Lower Thames Crossing

5.4.1.6 Draft Agreed Statement of Common Ground between (1) National Highways and (2) Natural England (Tracked changes version)

DATE: November 2023

*Local Landscape Character Area boundaries of the Kent Downs AONB LCA, West Kent Downs, Sub-areas Cobham and Shorne*

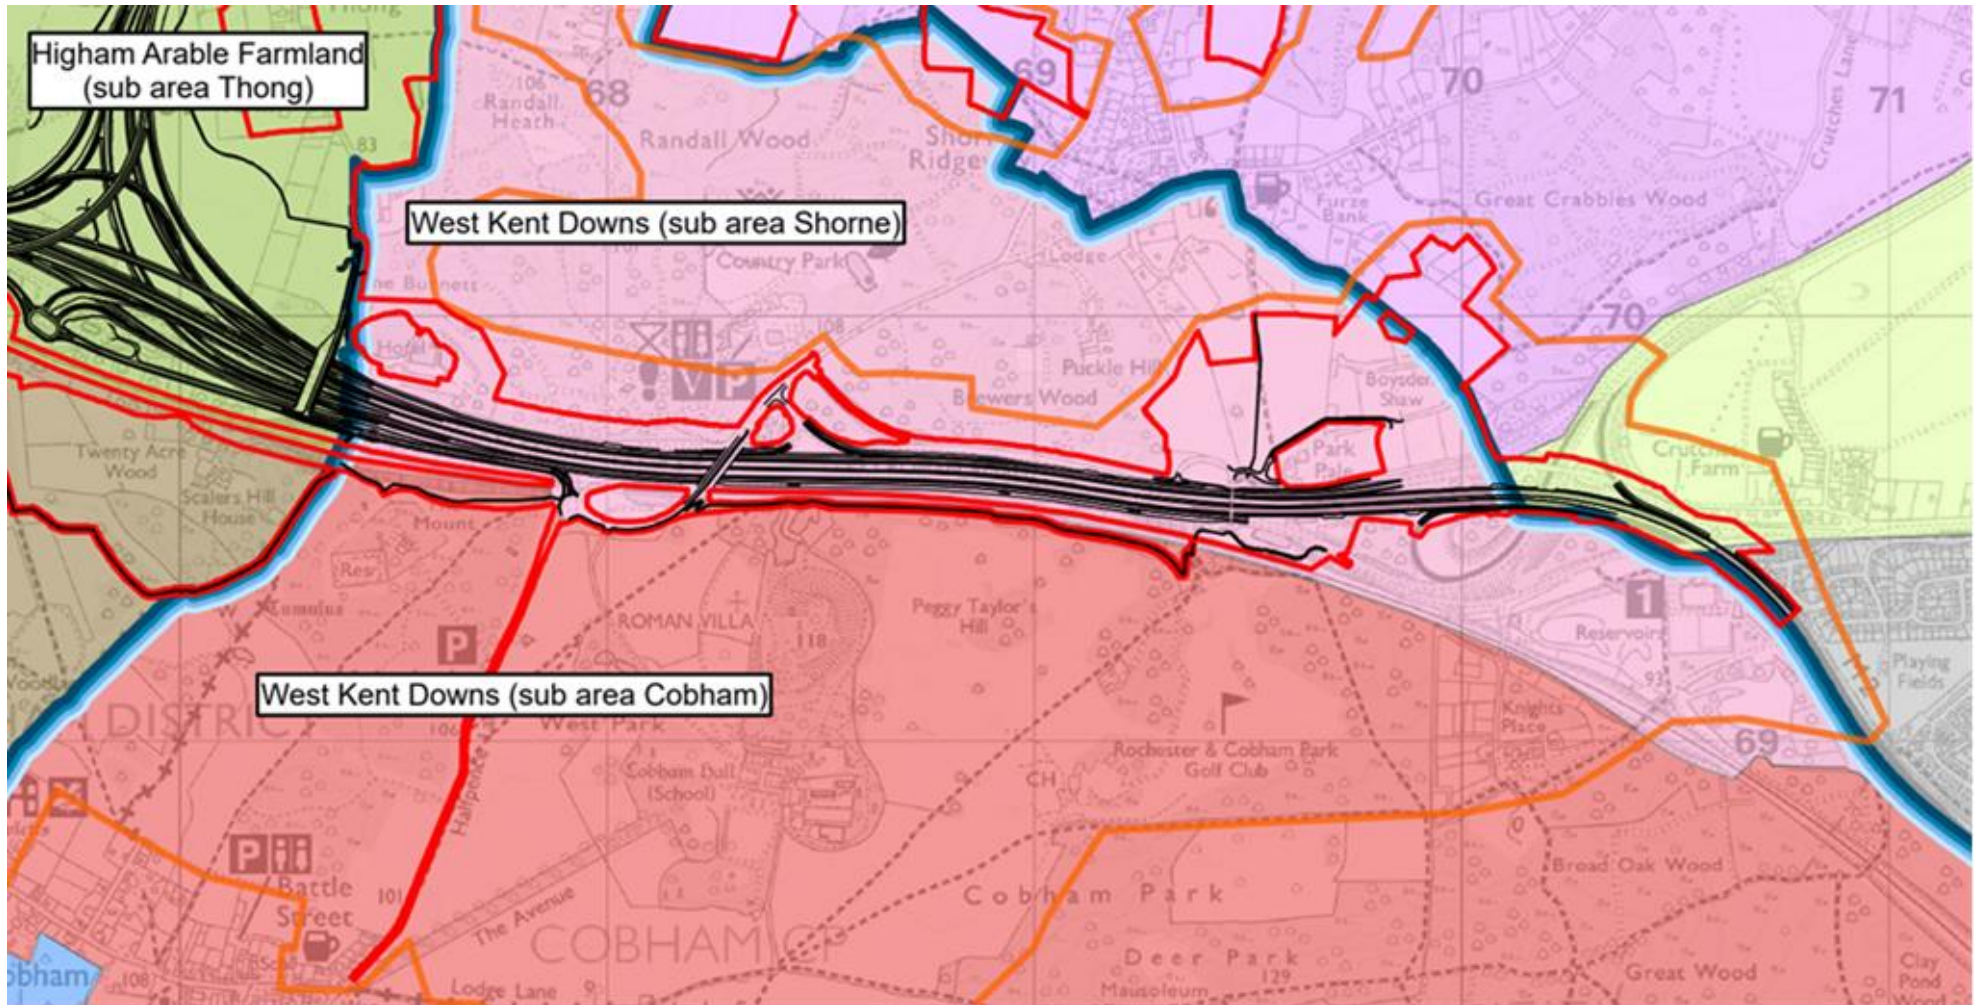
Topic	Item No.	Natural England Comment	The Applicant's Response	Application Document Reference	Status
				– 10.1.4 [REP1-262]	
Landscape and visual					
Visual					
Baseline	2.1.105 WR (DL5)	The Environmental Statement appears to show incorrect boundaries for the contiguous West Kent Downs (sub area Cobham) and West Kent Downs (sub area Shorne) Local Landscape Character Areas (LLCA). The Cobham sub area boundary largely follows the northern boundary of the existing A2/High Speed 1 Rail Line alignment whereas the Environmental Statement shows the same Character Area boundary running to the south of the A2/High Speed 1 Rail Line. The incorrect transposition of the boundaries for these two sub -Character Areas is likely to mean that the assessment of landscape and visual effects within the Environmental Statement are incorrect.	The boundaries of the LLCAs within the Kent Downs AONB have not been incorrectly transposed. As detailed in Appendix A of Comments on Written Representations, the boundaries of character areas identified in the studies have been used to inform the definition of the LLCAs, which have been used as a basis for the assessment of effects on the landscape at the local level. In a limited number of locations, the boundaries of the published character areas have been slightly adjusted through detailed study and analysis undertaken for the LVIA. Notwithstanding this slight difference in the West Kent Downs (sub area Cobham) LLCA boundary, the effects of the Project are fully assessed either as direct or indirect effects within the West Kent Downs (sub area Cobham) LLCA and/or the neighbouring West Kent Downs (sub area Shorne) LLCA.	ES Chapter 7: Landscape and Visual [APP-145] Comments on Written Representations Appendix A- Statutory Environmental Bodies [REP2-046] Natural England's Written Representation paragraphs 6.1.3, 6.1.4 and 6.1.7 [REP1-262]	Matter Not Agreed

Topic	Item No.	Natural England Comment	The Applicant's Response	Application Document Reference	Status
			The findings of these two assessments are then brought together into a combined assessment for the overarching West Kent Downs Landscape Character Area (LCA) 1A. The combined effects reported in the landscape impact summary Tables 7.33 and 7.34 in Section 7.9 of ES Chapter 7: Landscape and Visual, and the overall conclusion of the landscape and visual impact assessment would therefore not differ if the Cobham and Shorne sub area boundary is drawn in a different location.		
Methodology	2.1.24	<p>The viewpoint locations have been agreed with Natural England.</p> <p><u>As detailed in Natural England's response to EXQ1 Q12.3.1 [REP4-388], we understood that visualisations were to be prepared for all of the agreed viewpoints as suggested within an email from the Applicant dated 19 April 2019. The Applicant. In their response to our answer [REP5-077] stated that their email of the 19 April 2019 was 'was not intended to imply that photomontages would be provided from all 89 Representative Viewpoints. The selection of a smaller range of key viewpoints from which to provide</u></p>	<p><u>The viewpoint locations have been agreed with Natural England.</u></p> <p><u>As detailed in Applicant's Comments on IP Responses to ExQ1 at Deadline 4 [REP5-077]. The Applicant's email to Natural England dated 11 April 2019 was not intended to imply that photomontages would be provided from all 89 Representative Viewpoints. The selection of a smaller range of key viewpoints from which to provide photomontages represents a proportionate approach to illustrating the Project and this approach is widely recognised as good practice.</u></p>	<p>ES Chapter 7: Landscape and Visual [APP-145]</p> <p>Natural England's Written Representation paragraph 6.1.5 [REP1-262]</p> <p><u>Applicant's Comments on IP Responses to ExQ1 at Deadline 4 [REP5-077]</u></p>	Matter Agreed
